OXFORDSHIRE COUNTY COUNCIL'S RESPONSE TO CONSULTATION ON THE FOLLOWING DEVELOPMENT PROPOSAL

Application no: 15/02103/REM-2

Proposal: Reserved Matters to application 06/00967/OUT - Provision of Local Centre to include Community Centre (Class D1), Youth Centre (Class D1), Nursery (Class D1), Convenience Store (Class A1), 4 x retail units (Class A1/A2/A3/A4 and/or A5) and associated development including public square, landscaping, car parking, recycling point and ancillary servicing yard off Whitelands Way, at the Kingsmere development, South West Bicester.

Transport

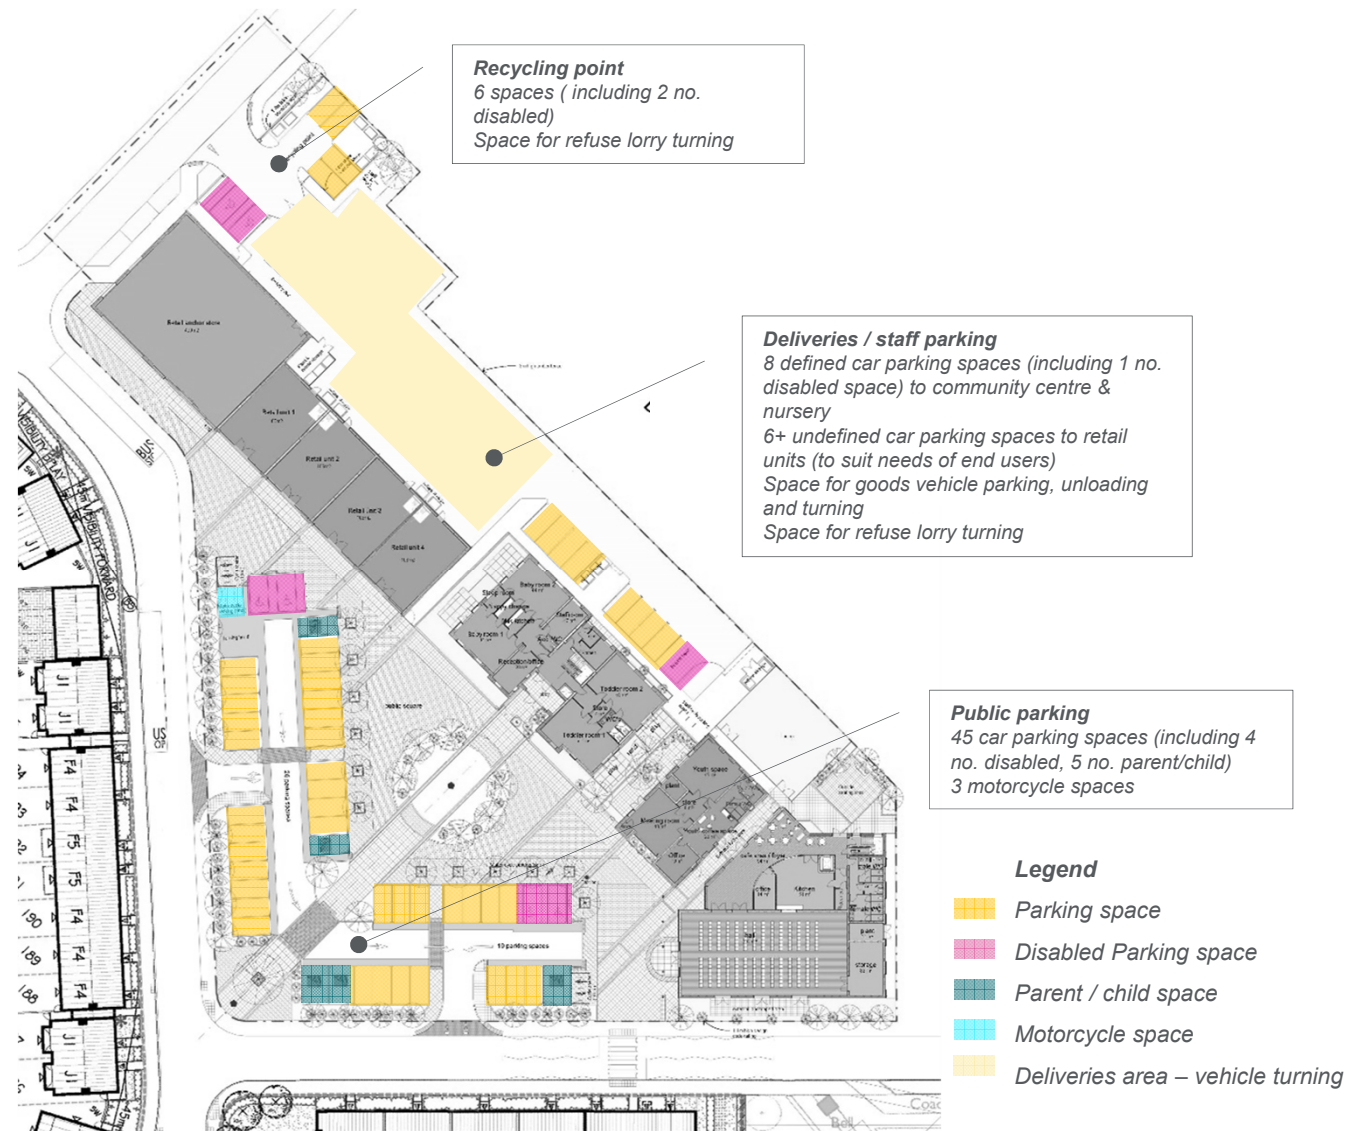
From drawing no **2226/LC/001 Rev M** I have noticed a change in layout of the parking and turning areas at the back of the nursery and retail units which I understand would be dedicated to staff. This would relieve the parking spaces at the front to be used solely by customers and visitors.

\\ser01bos1uk.wspgroup.com\projects\south_bicester\drawings\autocad\2779-atr-008.dwg, 17 June 2016 15:56:59, Anees, Arif

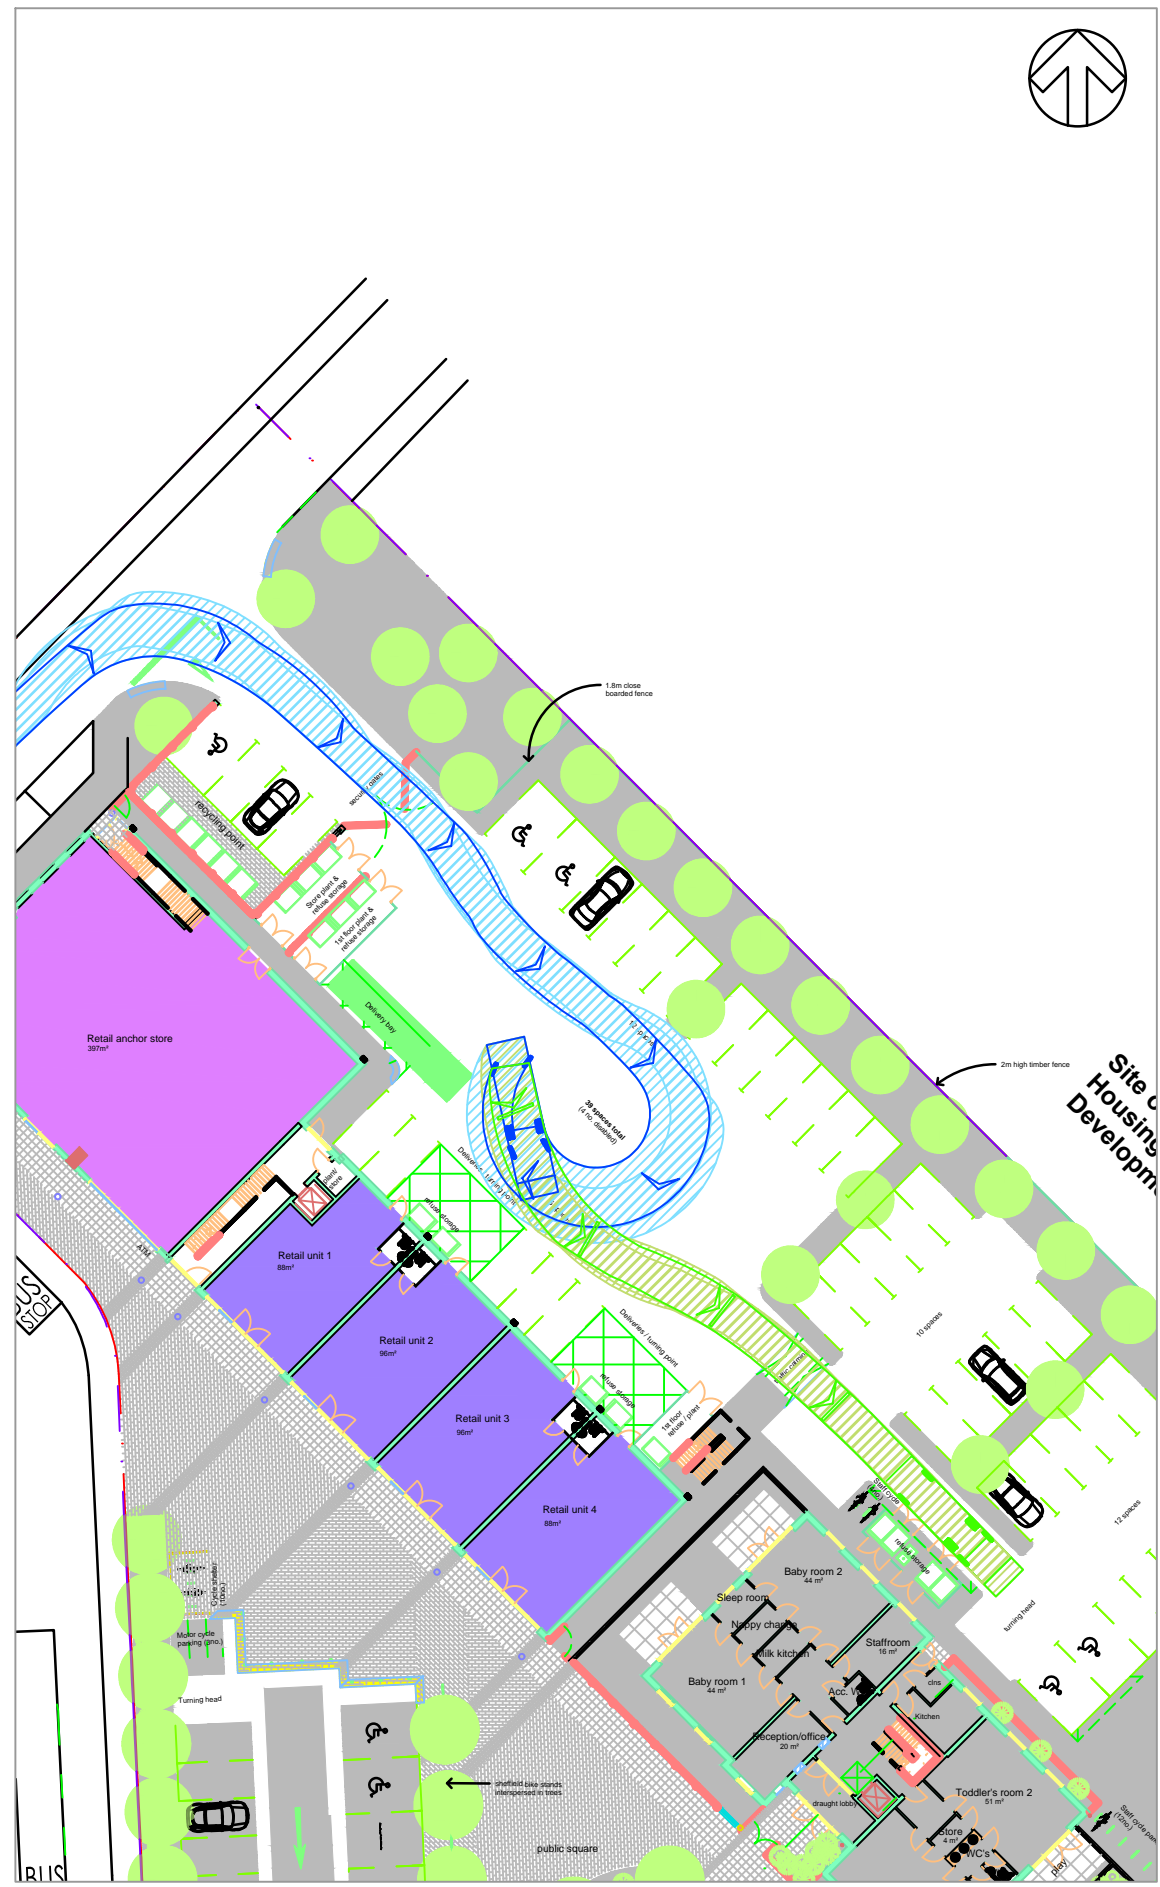
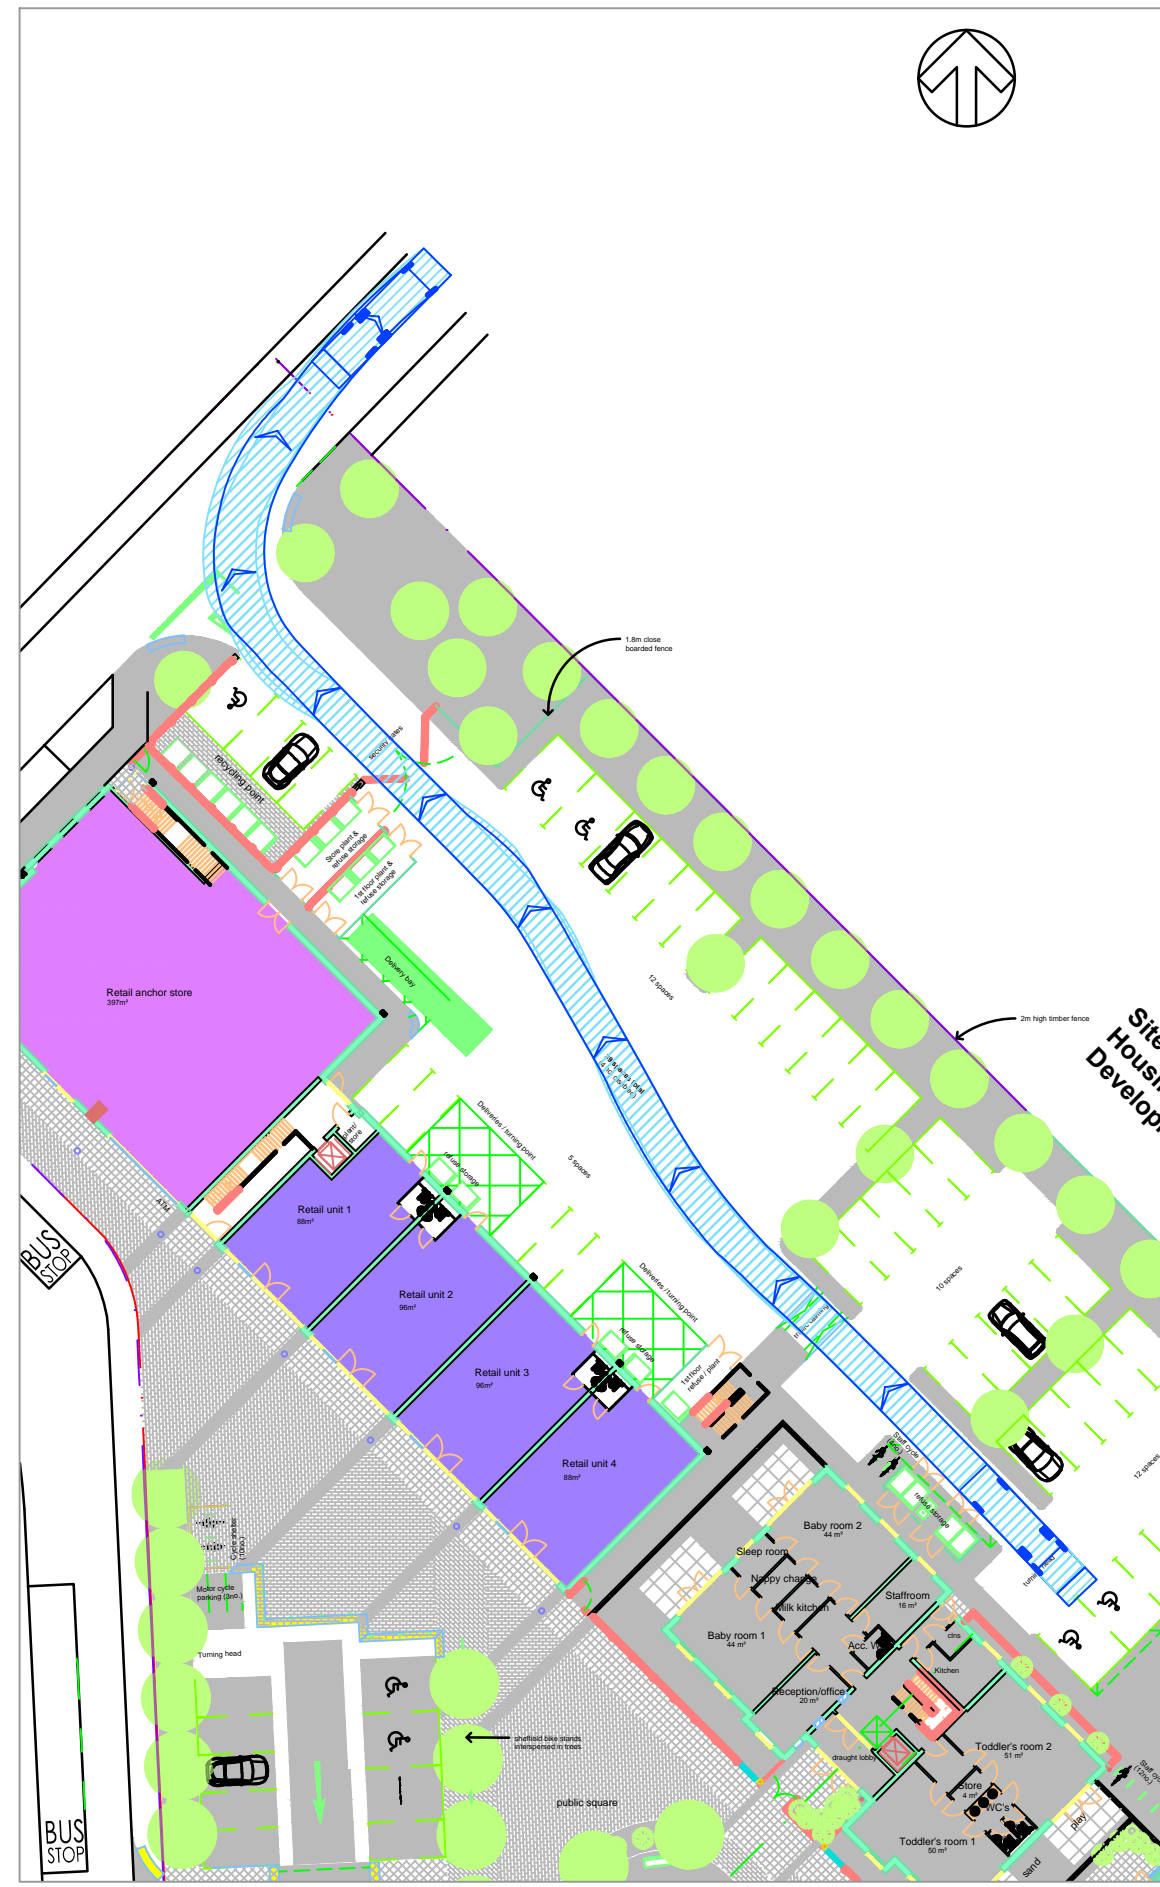
Whilst am pleased to see a better layout, I am equally concerned with the lack of tracking for large vehicles in this area. Swept path analysis for a large size delivery vehicle preferably an articulated lorry was previously requested for. Since the occupant of the retail anchor store (convenience store) is unknown at this stage, tracking for an articulated trucks is recommended to show that possible future deliveries made by all types of trucks to the store can be safely accommodated on site.

Drawing no **2226/LC/001 Rev M** also shows refuse storage points for nursery, youth centre and community hall located further down the bottom of the staff parking area. I am particularly concerned by the arrangement which is likely to make it impossible for the bins (serving the youth centre and community hall) to be accessed past the pair of DDA parking spaces should the parking spaces be occupied. The turning head adjacent to the nursery appears to be tight for any operational purposes.

The applicant must therefore demonstrate manoeuvrability of a 10.5m refuse collection truck to within reasonable reach of the refuse collection areas which have to carefully be incorporated in the layout design.
